Ribble Valley Borough Council
Housing & Development Control

Your ref: 3/2022/0722
Our ref: D3.2022.0722
Date: 17th October 2022

Application no: **3/2022/0722**

Proposal: **Proposed agricultural steel frame building for the storage of forestry equipment and building machinery in connection with 2 rural based businesses, including an access track.**

6707 - P02 REV E

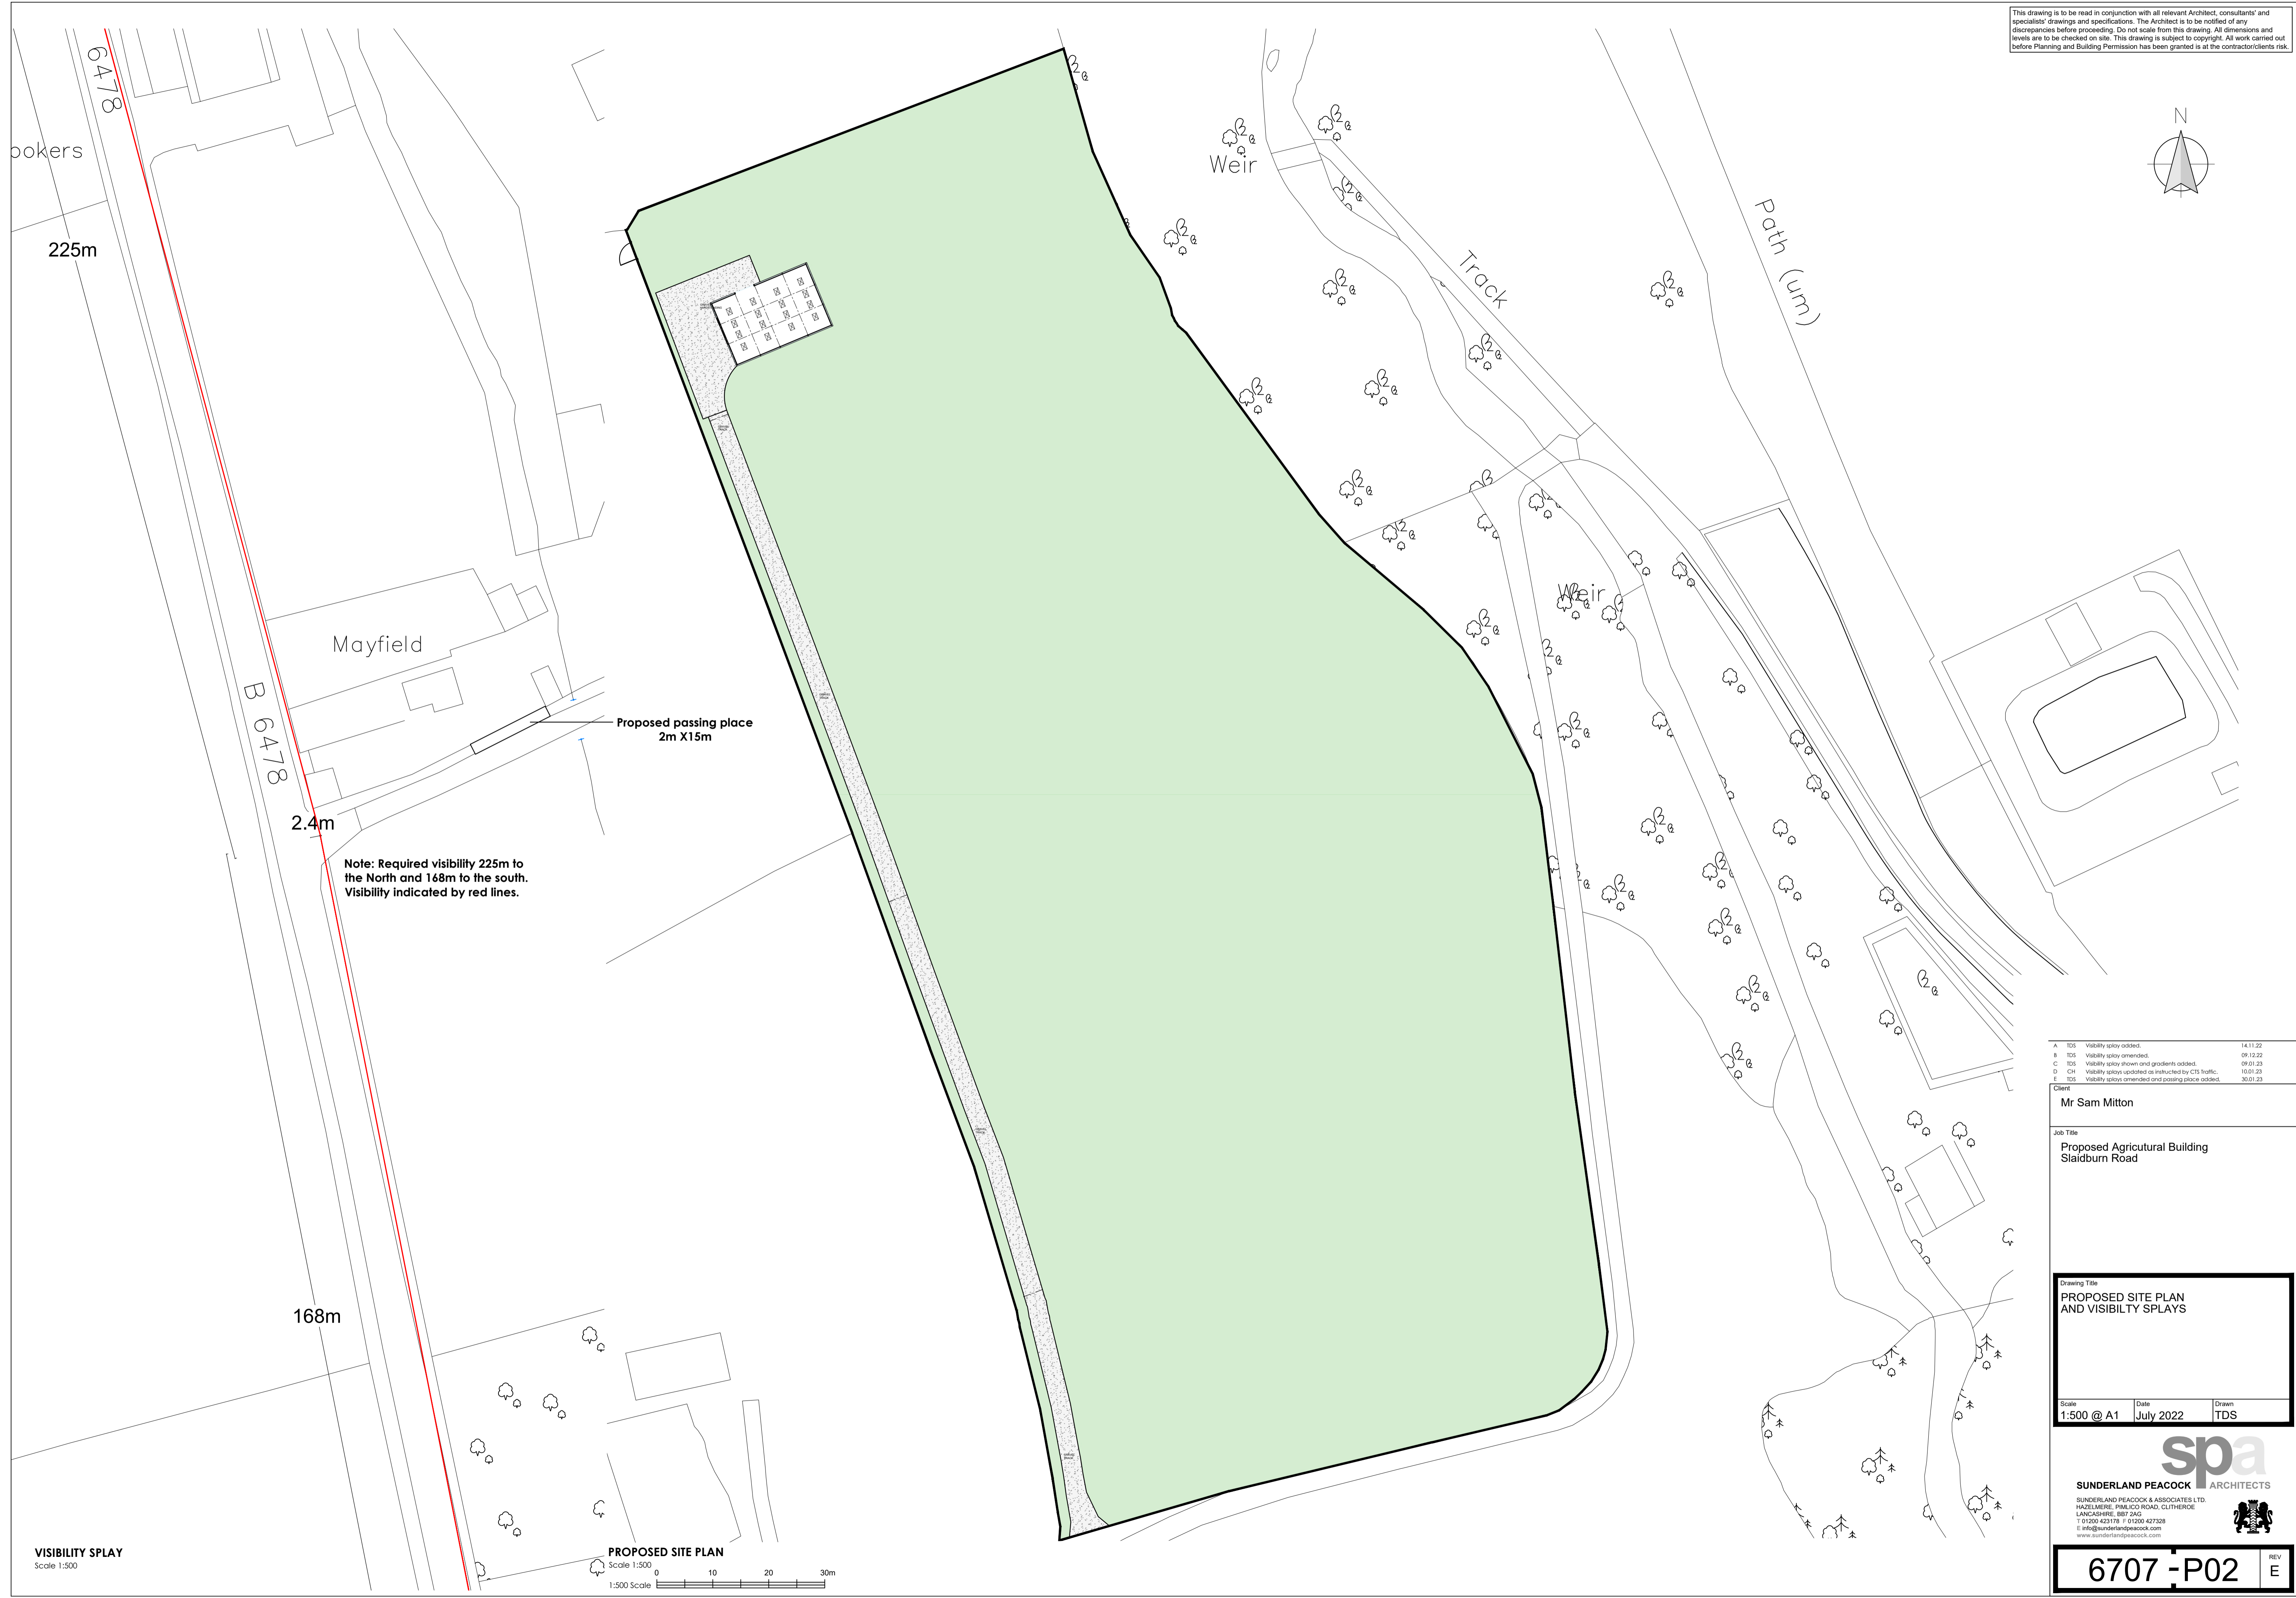
The LHA are also requesting that a more a detailed site access plan is submitted showcasing the access width and visibility splays. The LHA remind the Agent that an access located off a 50mph road is required to provide visibility splays of 2.4m x 148m in both directions.

Should the access not be able to achieve the minimum visibility splays, the LHA will require a speed survey to be conducted to determine the 85th percentile speeds within the vicinity of the site access. The speed survey should then be supported by a vehicular visibility splay drawing showcasing the maximum visibility the site can provide.

In any case, the LHA have reviewed the proposed access track which will provide a vehicular link to the existing unadopted track and are aware that that the proposed track will be approximately 1.1m wide as shown on SPA drawing number 6707-P02 titled "Proposed Site Plan." This does not comply with the LHAs guidance, which requires an access track to be a minimum of 3.5m wide. Therefore, the LHA require an amended plan to be submitted to ensure that the minimum width of the access track is implemented.
